Waddington Parish Council

Tuesday, July 14th 2020

Ref: Planning application 3/2020/0424 Demolition of existing dwelling and erection of replacement two-storey dwelling; Parsons Croft, Slaidburn Road, Waddington, BB7 3JQ

name
site plan - proposed

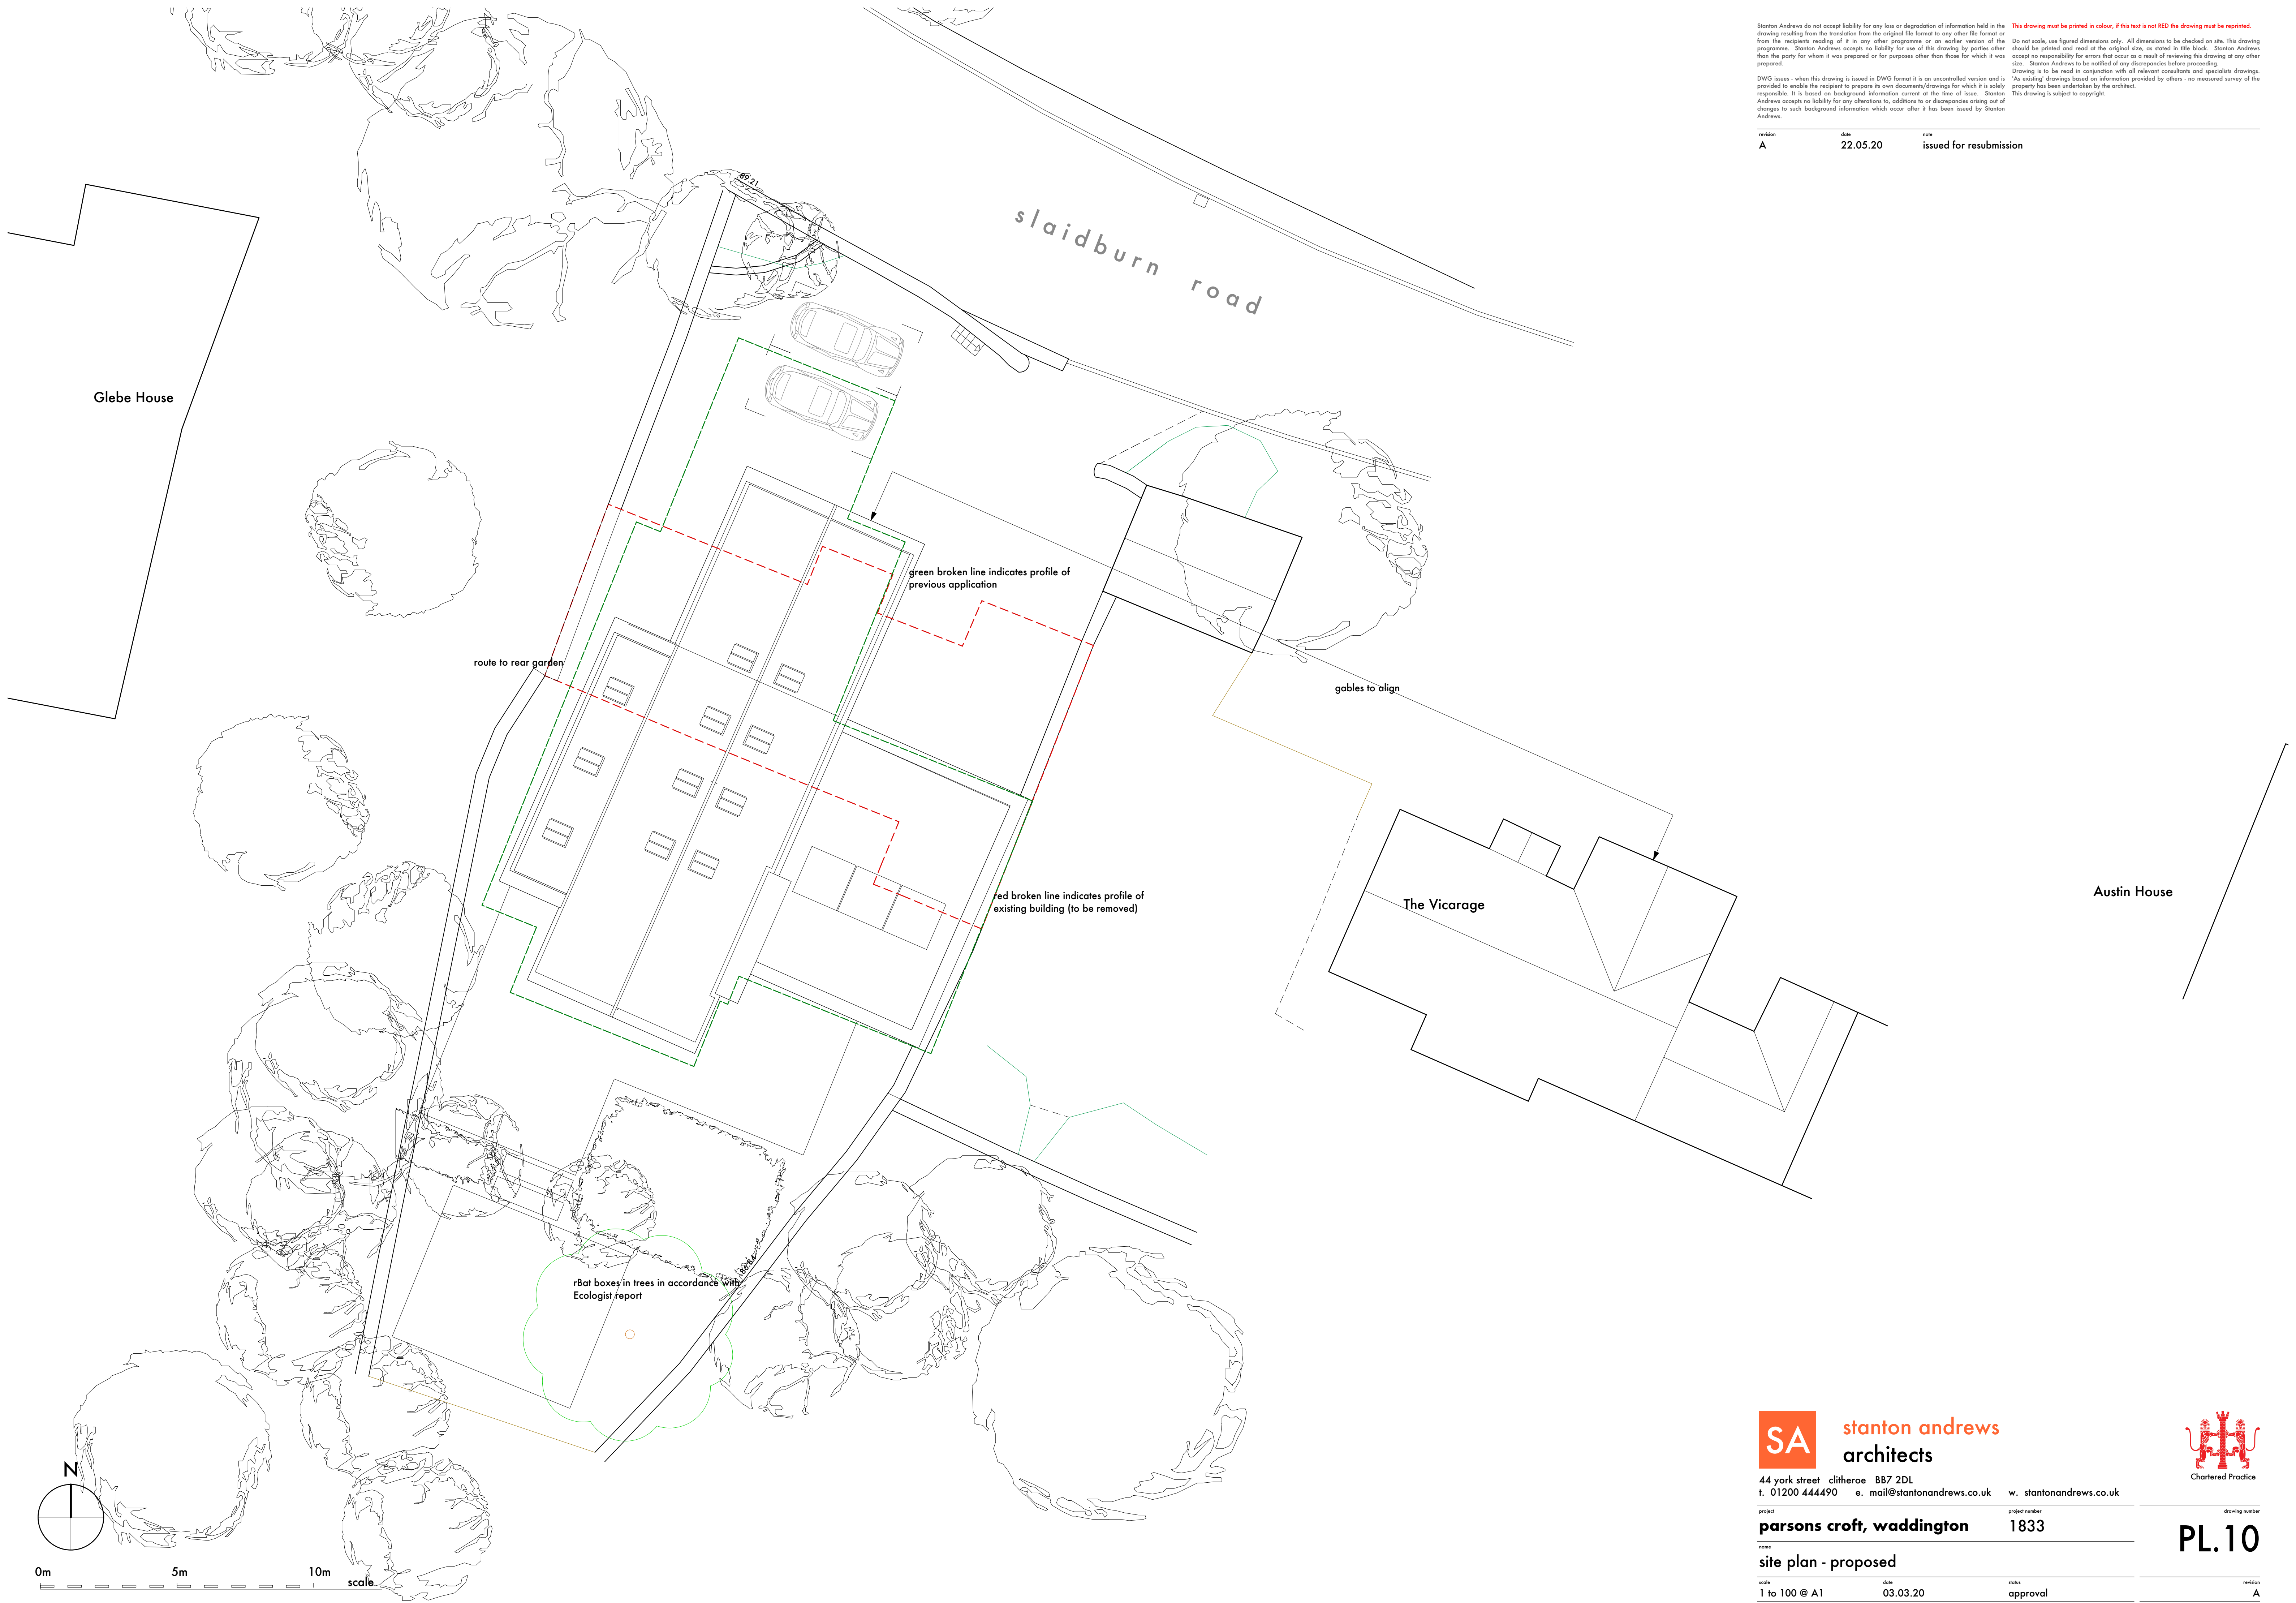
- The size of the proposed two-storey dwelling is out-of-scale in terms of other properties in the locality;
- The size is unsuitable in terms of size and mass – it seems to be twice the size of the building it would replace;

- As a result of this large-scale dwelling there would be a detrimental effect on the conservation area as effectively the site will have been over-developed if permission is granted;

- Neighbouring properties will suffer both a loss of light and privacy;
- The planned build would have an adverse visual impact on the village landscape and locality;

- There are associated issues regarding highway safety for vehicles on Slaidburn Road.
